Submission ID: SFA6C1F04

Representation by
E B Gowing & N & J Gowing

Norwich to Tilbury Deadline 1 Submission

IMPACT STATEMENT

Image A14.5.1 EFC-400 Wet Noise Prediction for Proposed Overhead Line (Tier 1 Screening)

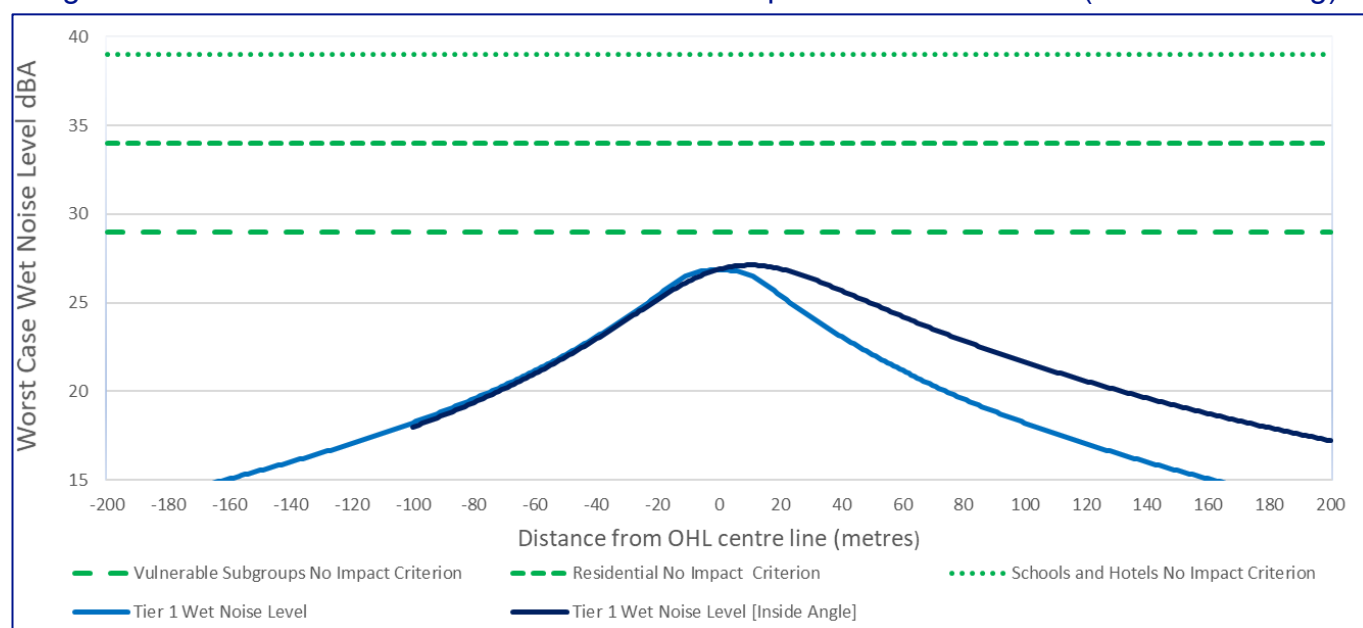
It is well known that overhead transmission lines and the associated pylons generate a persistent humming or crackling noise, particularly in wet weather. There has been a noticeable increase in audible intrusion from the 4YM line since the circuitry was increased and the wires and insulators renewed in 2024 and 2025. This raises significant concerns about increased disturbance from the proposed overhead cables and pylon which will be 215m closer to our home than 4YM is. This problem will be especially bad during evenings and early mornings when ambient noise levels are low.
